Response to WSCC Strategic Planning Consultation Comments dated 6 September 2012

**Roundstone Lane, Angmering
Arun Planning Application A/82/12**

Barratt David Wilson Southampton

23 November 2012

NOTES:

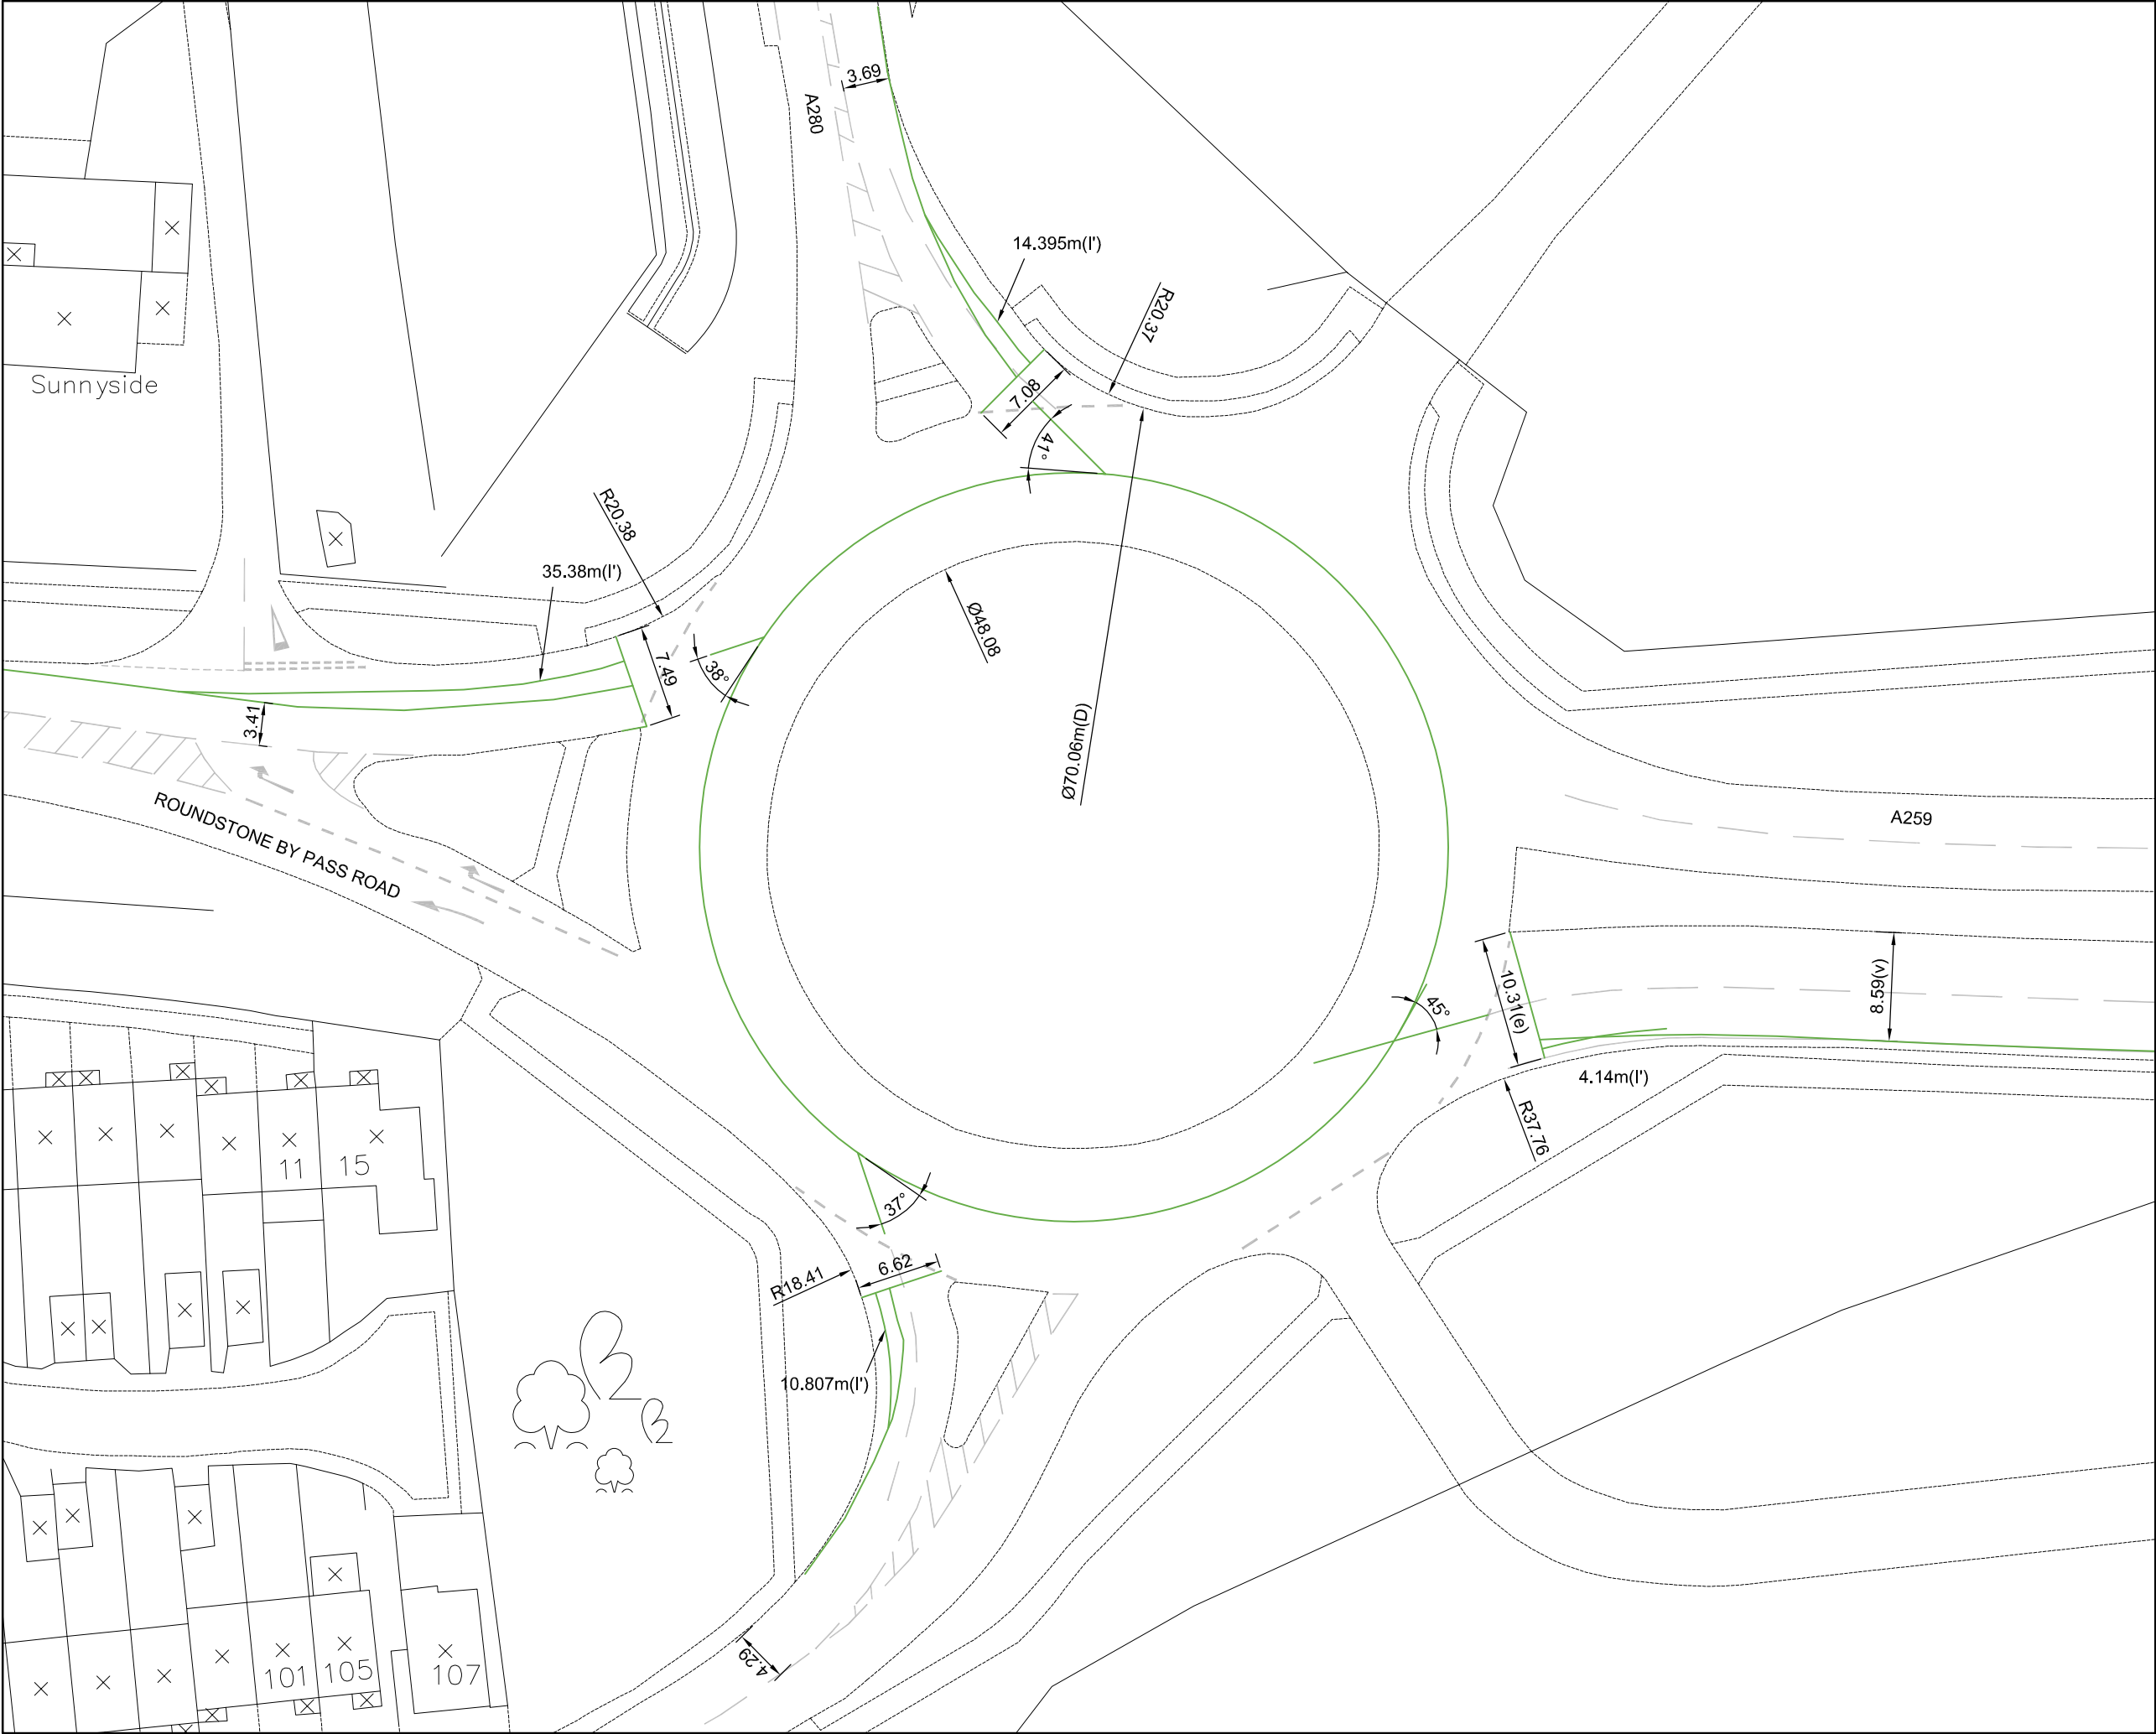
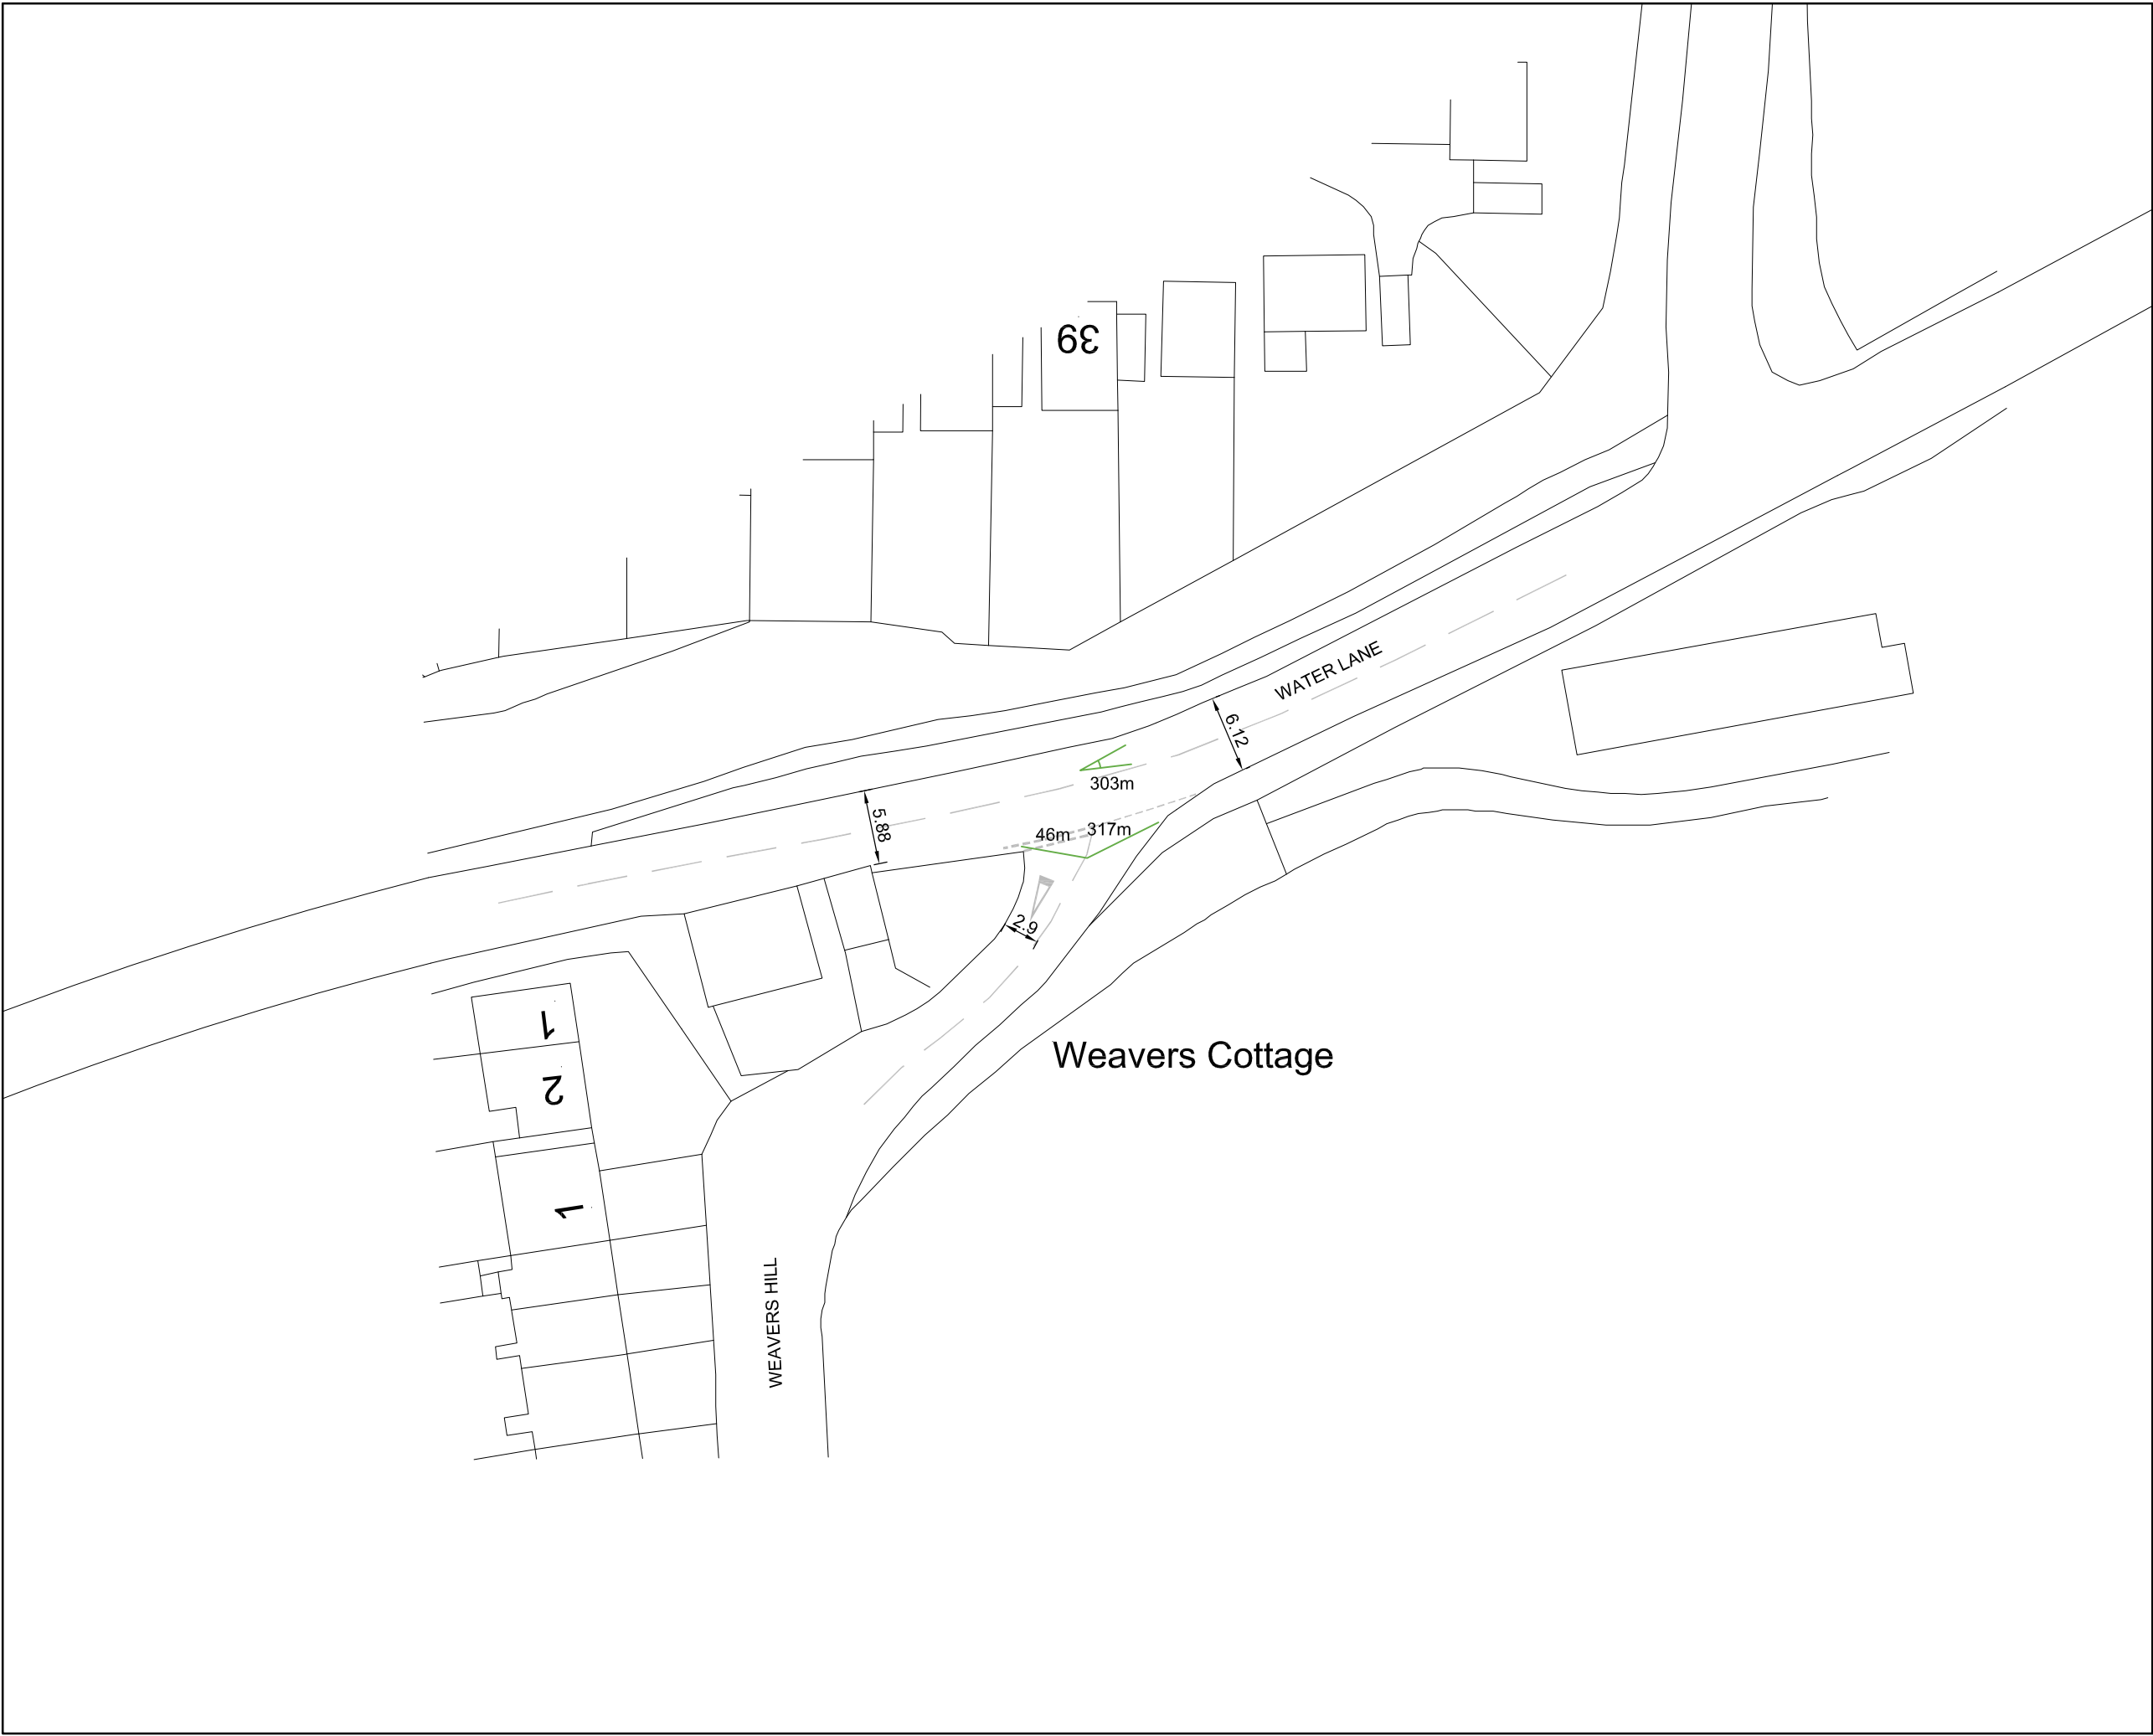
Junction assessments: These do not appear to be consistent with observed traffic conditions on the A259 or at Water Lane/A283. The queue lengths in Appendix 11 appear to be lower than actual observed queue lengths during the morning and evening peak hours. Further detail should be provided on the junction assessments relating to the A259 to explain the relationship between observed congestion and the technical junction assessments.

Queue length data taken during the traffic survey together with a summary in table and also schematic format is attached in Appendix 1 at the rear of this note.

The observed lengths in vehicles were noted every five minutes by the survey company. The summary queue lengths compiled by us from this data are mean average PCUs to match the definition of queue in TRL's ARCADY method. Capacity models are based on geometrical measurements taken from Ordnance Survey and aerial photograph. Percentage arm capacity adjustments have been undertaken where necessary such that the output from the ARCADY base model shows similar results.

We believe this industry standard approach provides adequately representative models however there are two reasons the traffic conditions observed might differ from the modelling results which are worth noting before attempting to produce more 'accurate' models:

1 – Natural variance and definition of queue. The queues reported from ARCADY are mean average static queues over time segments. This does not include slow moving traffic approaching a junction or demonstrate the maximum observable number of stopped vehicles at any particular time or any particular day. It can be seen from the raw queue length data that as expected at peak times there is a significant variance in queue length. There would also be significant daily variance not able to be incorporated into the models.

2 – Congestion from downstream delays beyond the roundabouts may have been observed which is not a capacity failing of the roundabout itself and would not be appropriate to artificially throttle the performance of the roundabout to mimic this since alteration to that roundabout would not solve the problem.

Nevertheless we believe the models represent the geometry and delay on the ground and produce a fair assessment of the likely increases in queue and delays due to development which are of course small in proportion to the small increase in traffic flow due to development.
